**INTAKE COMMENT (BUILDING):**

**INTAKE COMMENT (BUILDING):**

Project _____
 Kzt Calculations _____

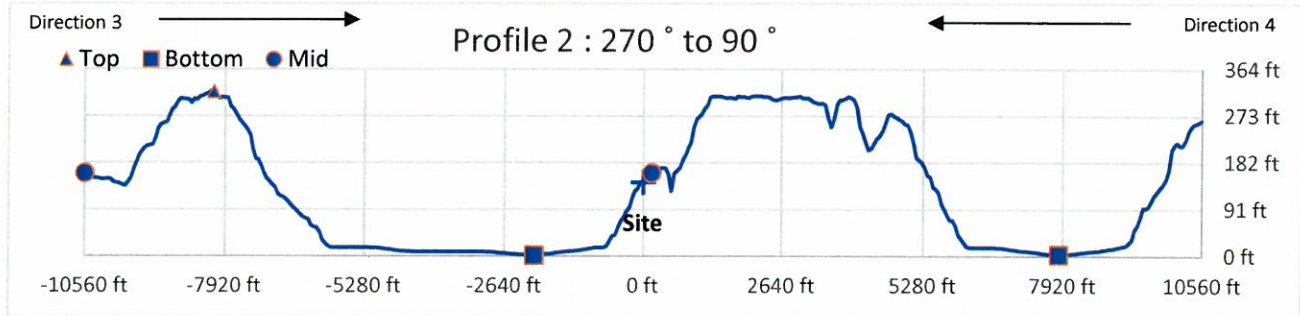
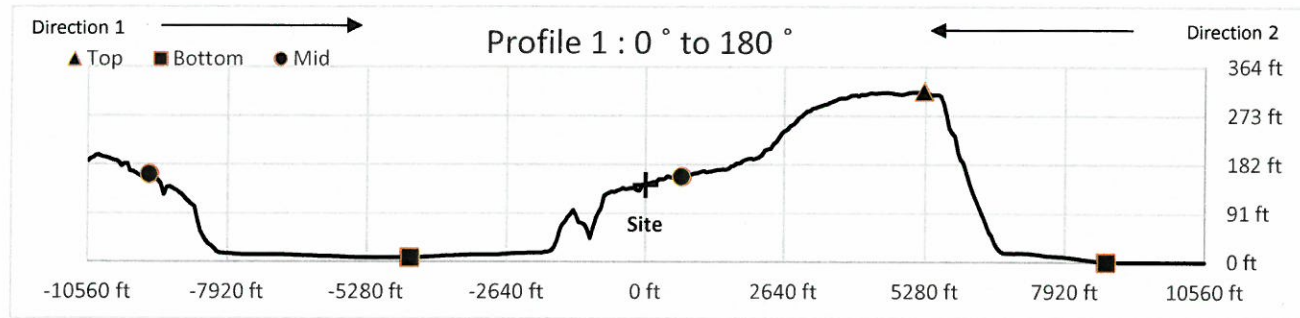
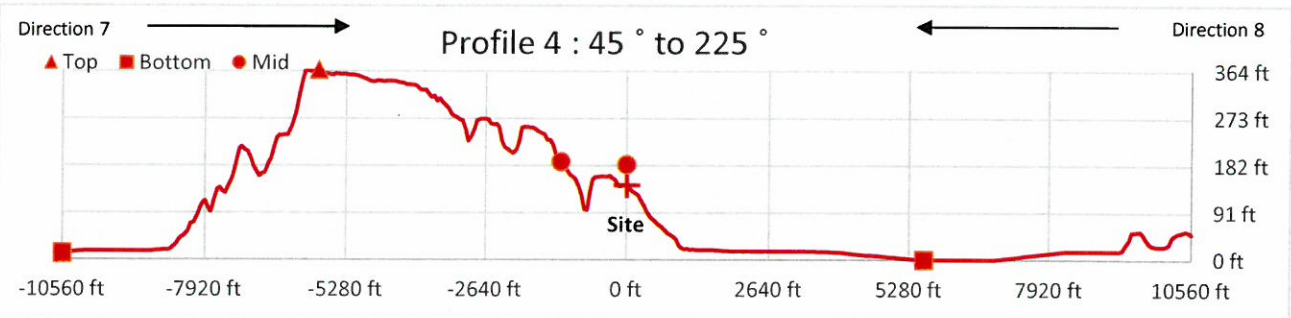
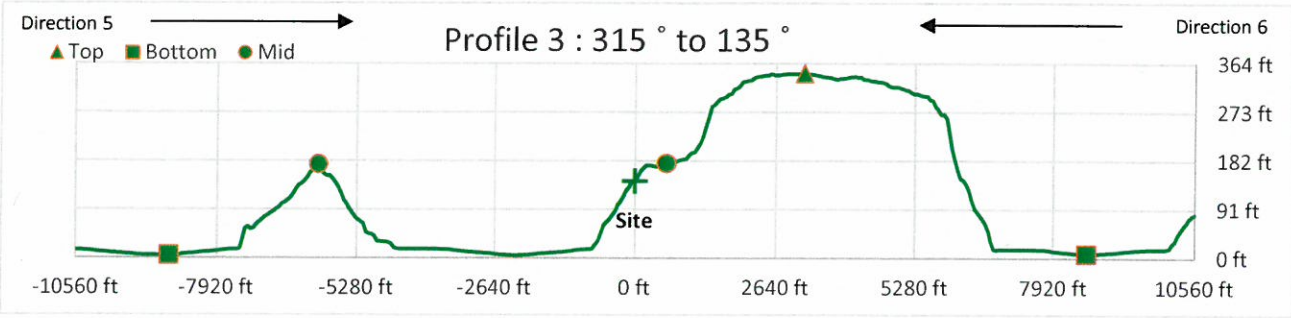
*Provide calculations for the determination of the Kzt Factor if the value used is less than that indicated on the City of Mercer Island Wind map: City mapping indicates a Kzt of 1.6, calculations reflect 1.0*

The Kzt factor (topographical effects) should be included only if all of the five conditions indicated in Section 26.8.1 of ASCE 7-16 are met. The last 11 pages of the structural calculations provide criteria sheets for both the detached gym building and the garage where we have provided calculations of the Kzt factors, including the determination of the five conditions indicated in Section 26.8.1.

Our analysis has concluded that the Kzt factor can be 1.0 based on Section 26.8.1 of ASCE 7-16 (see file 'ASCE 7-16 Kzt Code Excerpt').
